Subject: Cowal Gold Underground MOD 1 – Optimisation modification (SSD-10367-Mod-1)(Bland Shire)

Attachment A

Detailed advice to DPE Planning & Assessment regarding the Cowal Gold Underground Mod 1 – Optimisation Modification (SSD-10367-Mod-1)

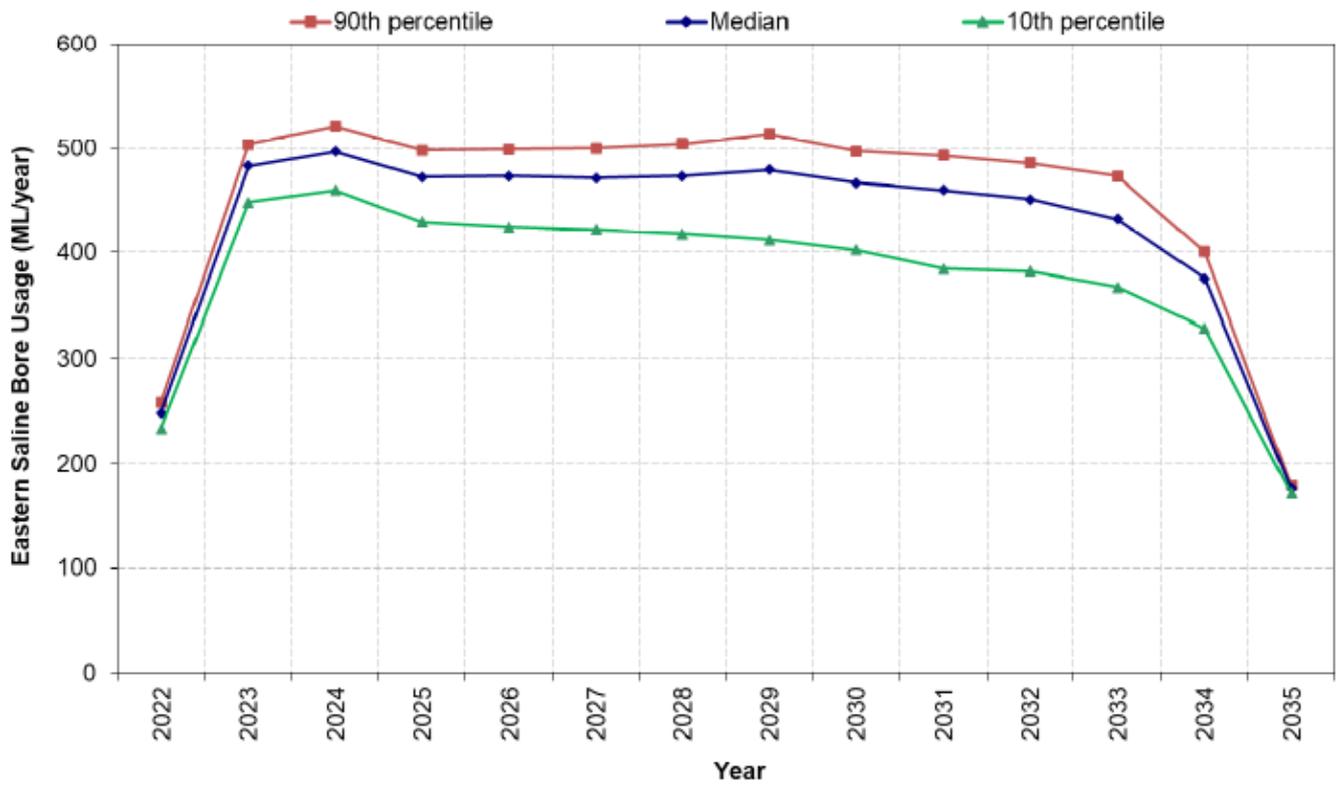
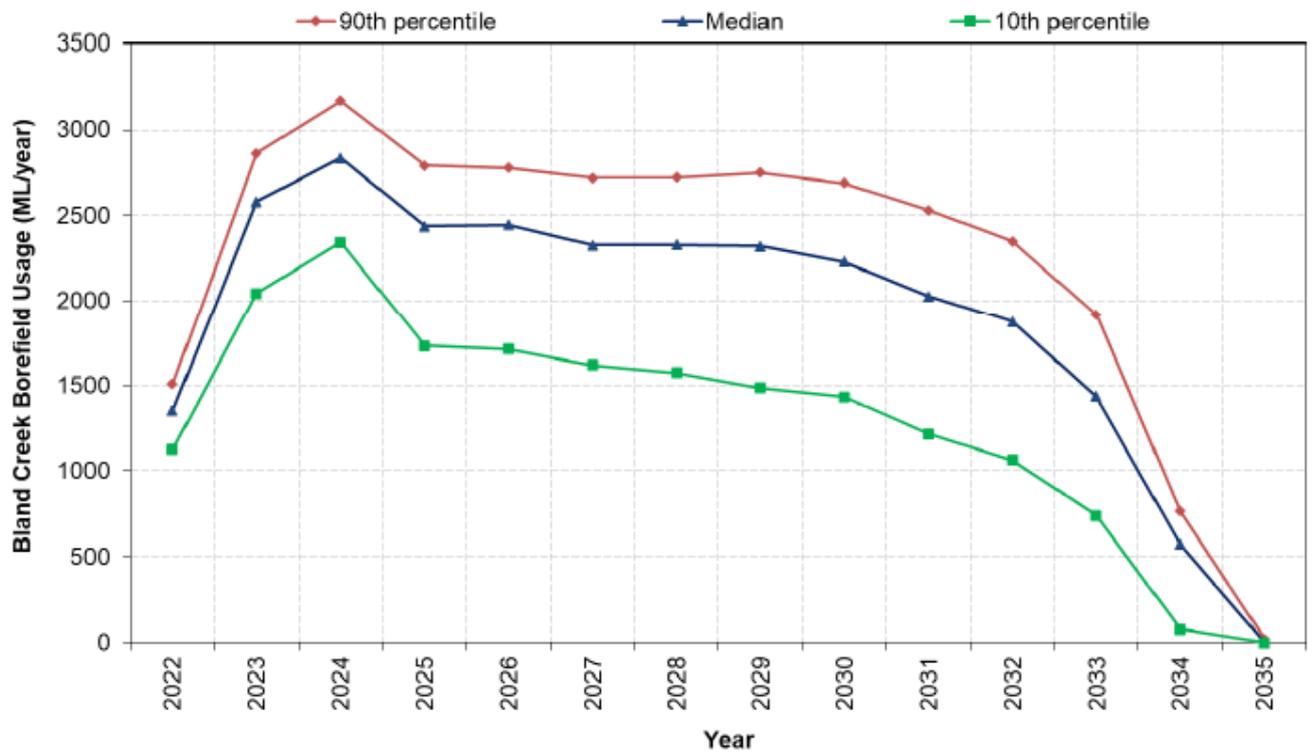
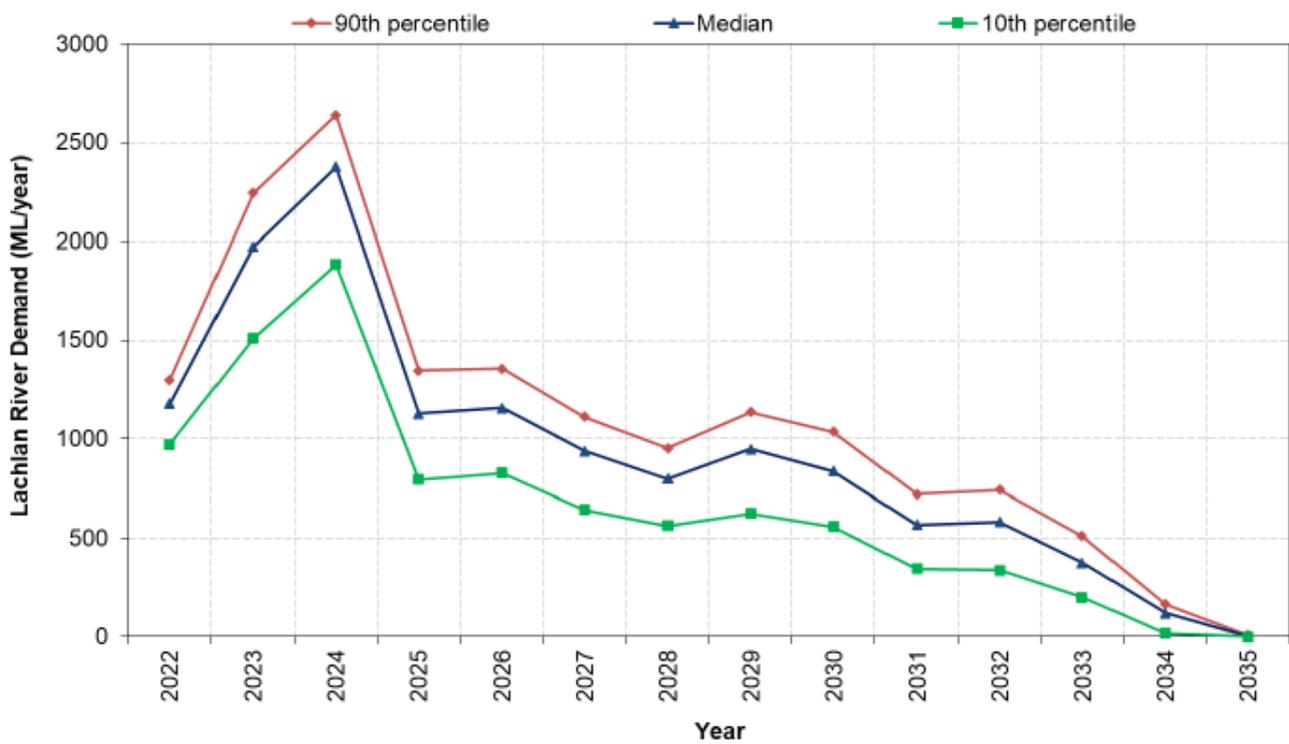
Section 6.4.3 in the Modification Report (Surface water impact assessment) includes the modification and approved project average groundwater demand from external sources (including Eastern Saline, Bland Creek Paleochannel borefields and Lachlan River), however it does not include maximum demand. It is also unclear why this is included in the surface water impact assessment.
